March 27, 2015

**Subject: Century Tire Plaza – 195 Kennebec Street
Project ID# 2015-027
Review Comments Received March 24, 2015**

VERTICAL GRANITE CURB INSTALLATION IN EXISTING STREETS

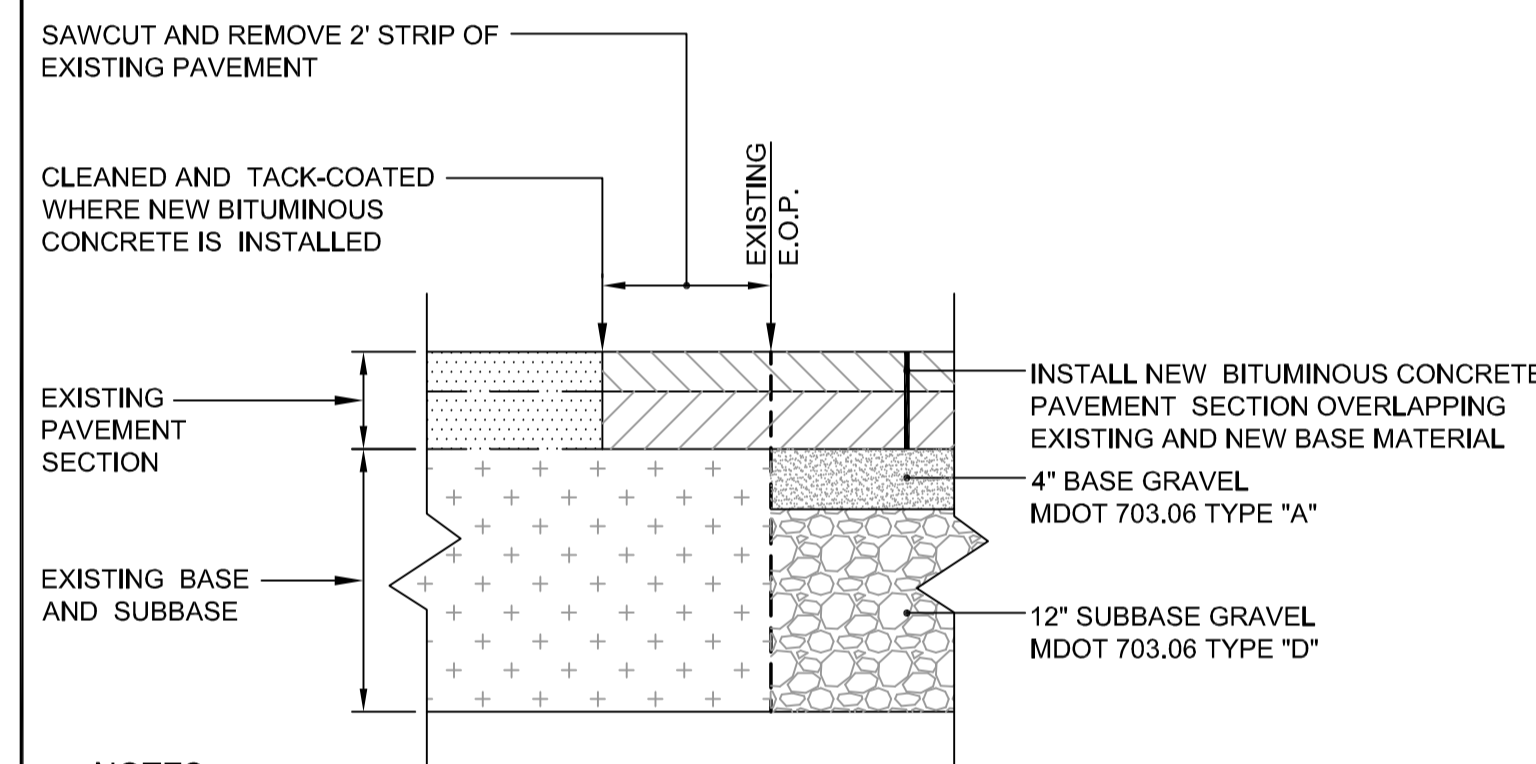
The curbing material standard within the road right of way for the City of Portland is granite. Concrete is indicated on Kennebec St.

The label for the proposed curbing material has been changed to indicate granite curbing at this location.

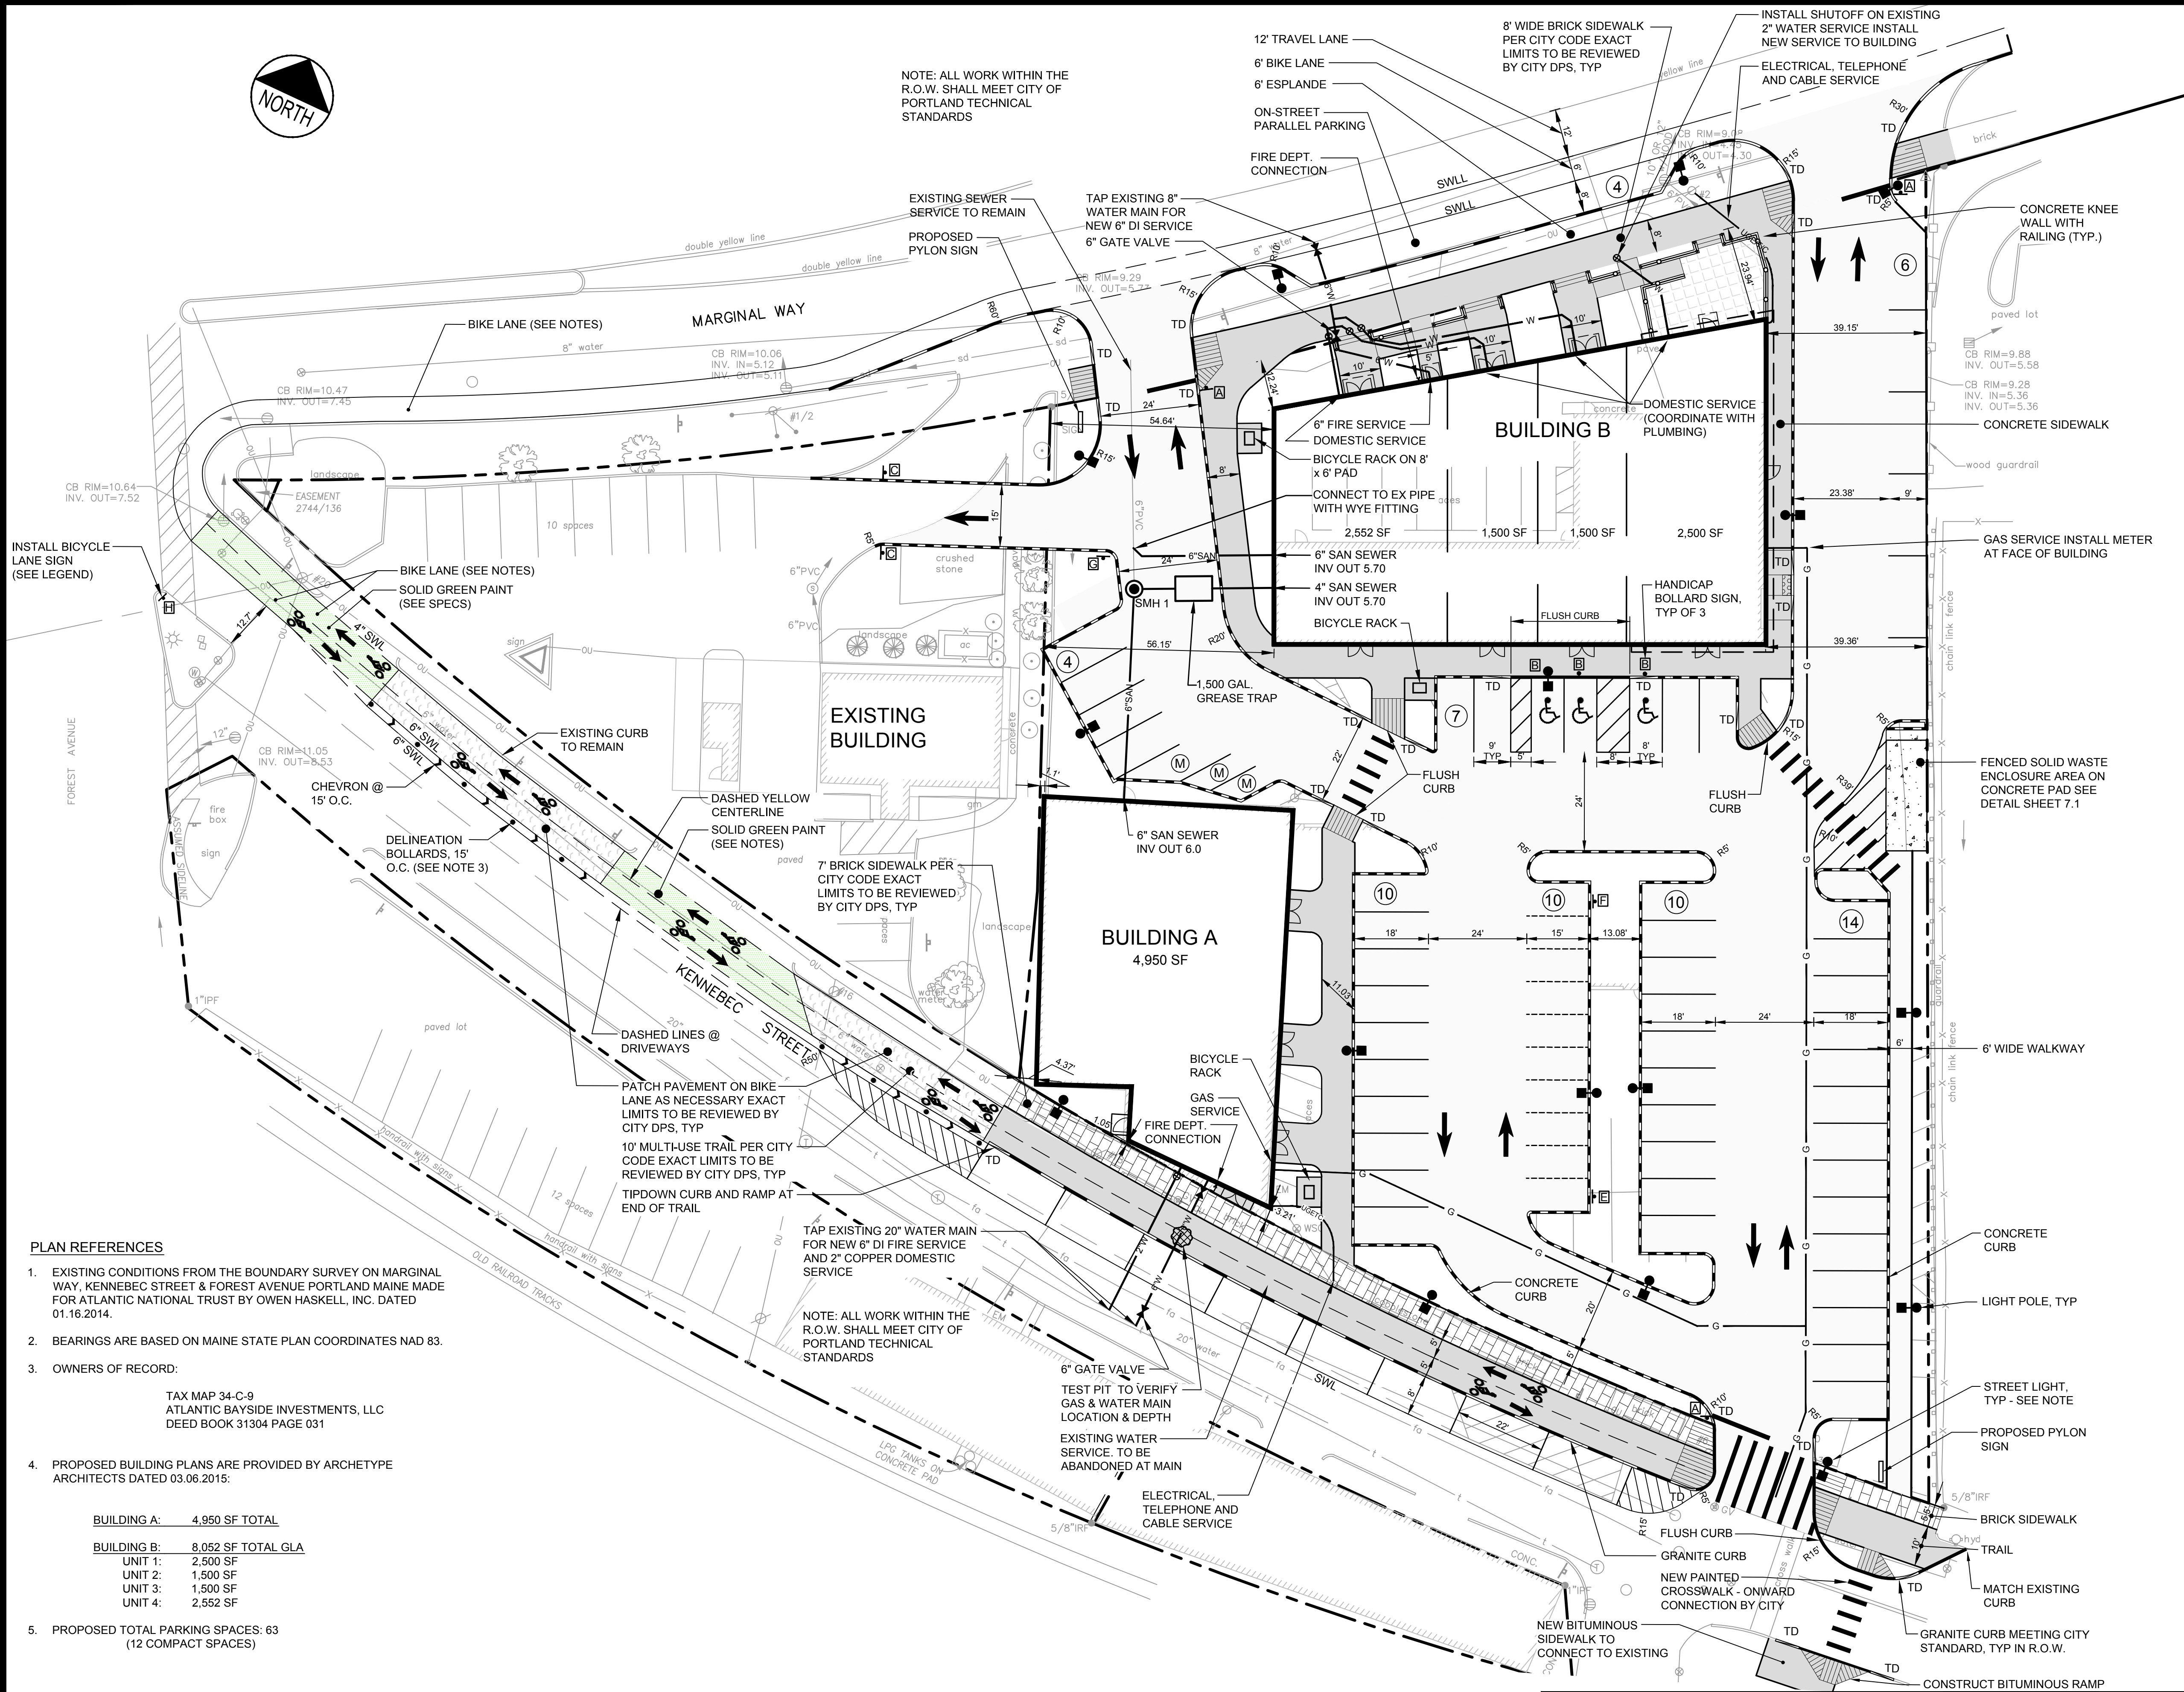
The project frontage on Marginal Way shall be adjusted to meet the design principles of the Marginal Way Master Plan (the nearby Gorham Savings Bank Building is a good example) . The plans should account for the following:

- On-street parking*
- The curb line should extend into Marginal Way and generally match the curb line at the Gorham Savings Bank site. The applicant should be cognizant of the transition from Forest Avenue and how vehicles will be aligned.*
- 10-foot brick sidewalk*
- 6-foot bicycle lane*

The frontage on Kennebec Street shall be adjusted to meet the design principles of the Somerset Street Extension project. The plans should account for the following:

- A 10-foot shared use bituminous path to be located next to the granite curb.*
- A 7-foot brick sidewalk along the property boundary.*
- On-street parking will not be permitted.*
- Transition of the shared use path to an on-road cycle track on both ends of the project will be required.*

The plans have been revised to show the requested curb line revisions and the addition of on-street parking, and a six-foot wide bike lane on Marginal Way. Striping has been added to delineate the bike lane.

The revised plans show the requested configuration on Kennebec Street, with the shared use path at the curb line and the brick sidewalk at the outside of the Right-of-Way. It should be noted that this is opposite to the configuration shown in the Somerset Street Extension Feasibility Study, dated January 2015. The multi-use trail transitions onto the existing street at the western end, as requested in the review comment above. The Design Engineer and the Applicant have significant concerns regarding the safety of this configuration. The end of the multi-use trail will potentially direct bicycle users onto the street directly opposing the current one-way traffic direction, and immediately adjacent to the heavily used exit to the Enterprise Rental facility. The trail configuration, and relationship to the adjacent site will need careful thought in order that a safe and efficient travel corridor is provided for all street users and to maintain the existing use, and future development potential for the adjacent property.

DRAWN: ADJ DATE: 11.25.14
DESIGNED: ADJ SCALE: 1" = 20'
CHECKED: ADJ JOB NO.: SP-M160
FILE NAME: SP-M160 BASE
SHEET: **C-3.0**

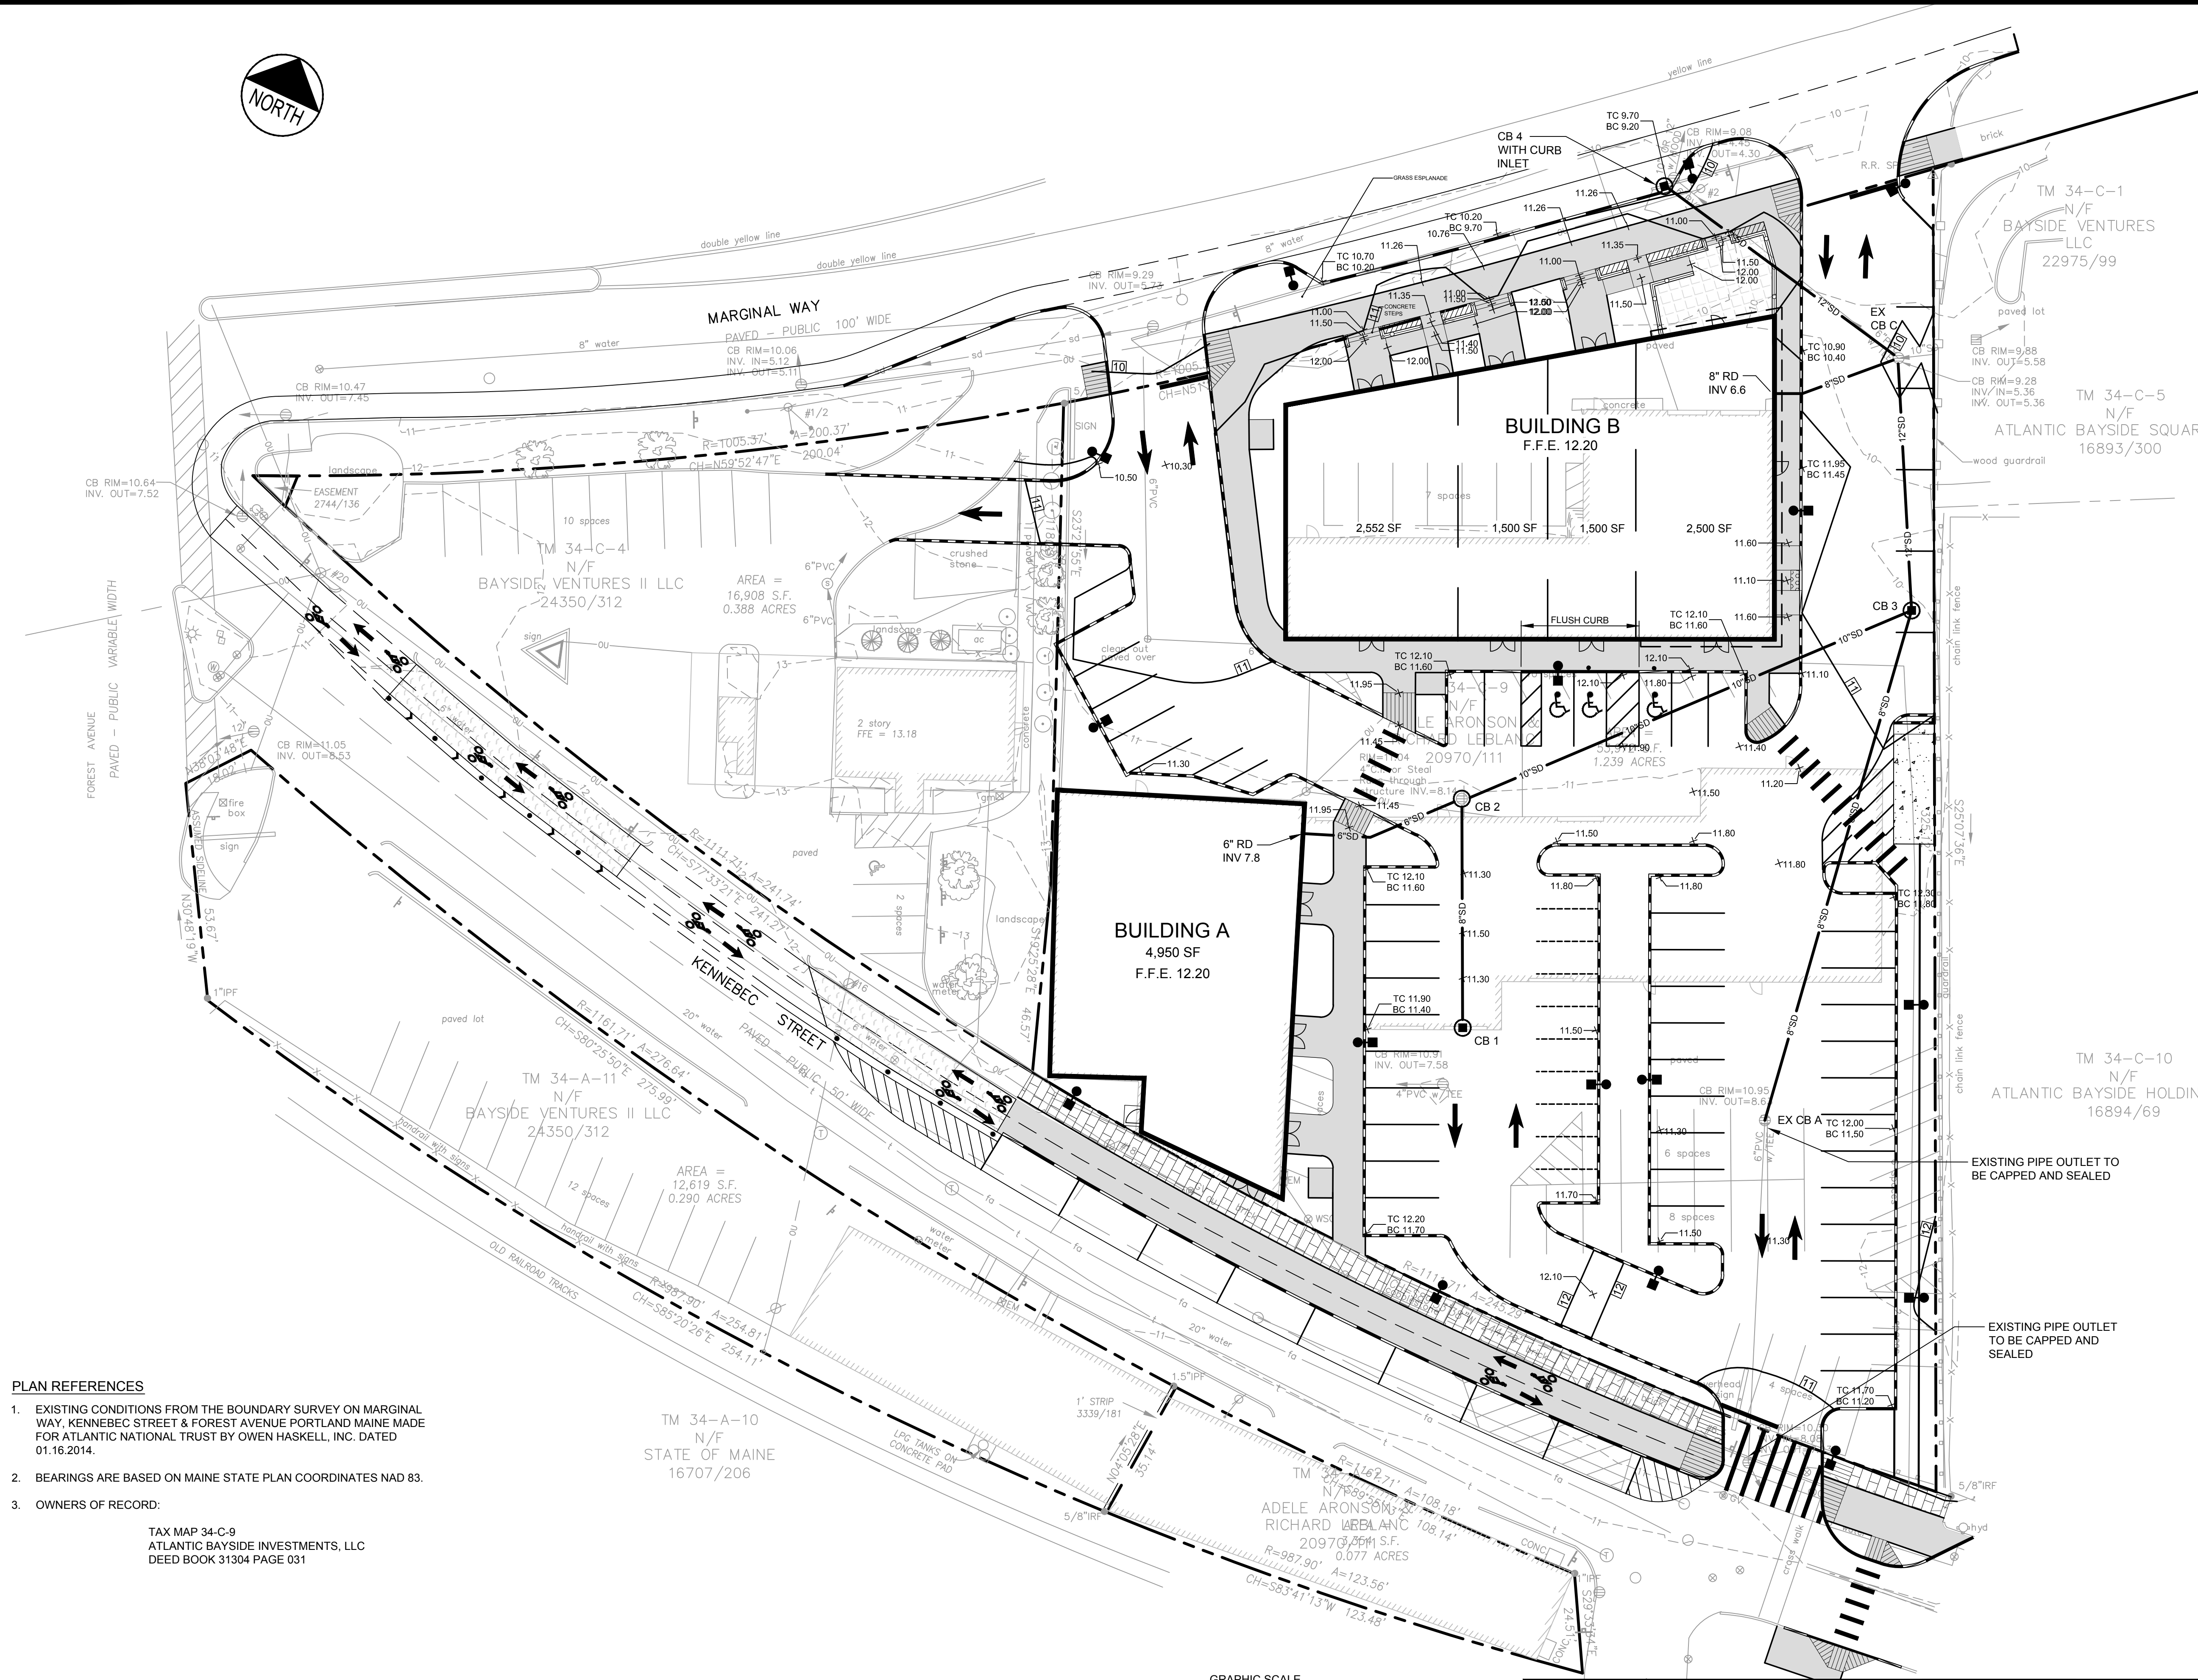
The Applicant proposes to install a new storm drain collection system for the majority of the site that will discharge to a catch basin connected to the combined sewer in Marginal Way. The Applicant proposes to preserve an existing Catch Basin "A" on the south side of the site, which connects to the Kennebec Street combined sewer system. The City anticipates installing a new, separated storm drain system in Marginal Way in the coming years; as such, the City requests that existing Catch Basin "A" be connected into the proposed system discharging to Marginal Way.

Since Marginal Way will have a new separated stormwater system in the near future, is it possible to convey drainage from existing CB A to proposed CB 1 and abandon lateral from existing CB A to CB with a rim of 10.30 in Kennebec St.?

The plans have been revised to show connection of the piping from Catch Basin A (now a new catch basin structure) to New Catch Basin 3, and hence to the system on Marginal Way, as requested.

The plans have been revised to show connection of the piping from Catch Basin A (now a new catch basin structure) to New Catch Basin 3, and hence to the system on Marginal Way, as requested.
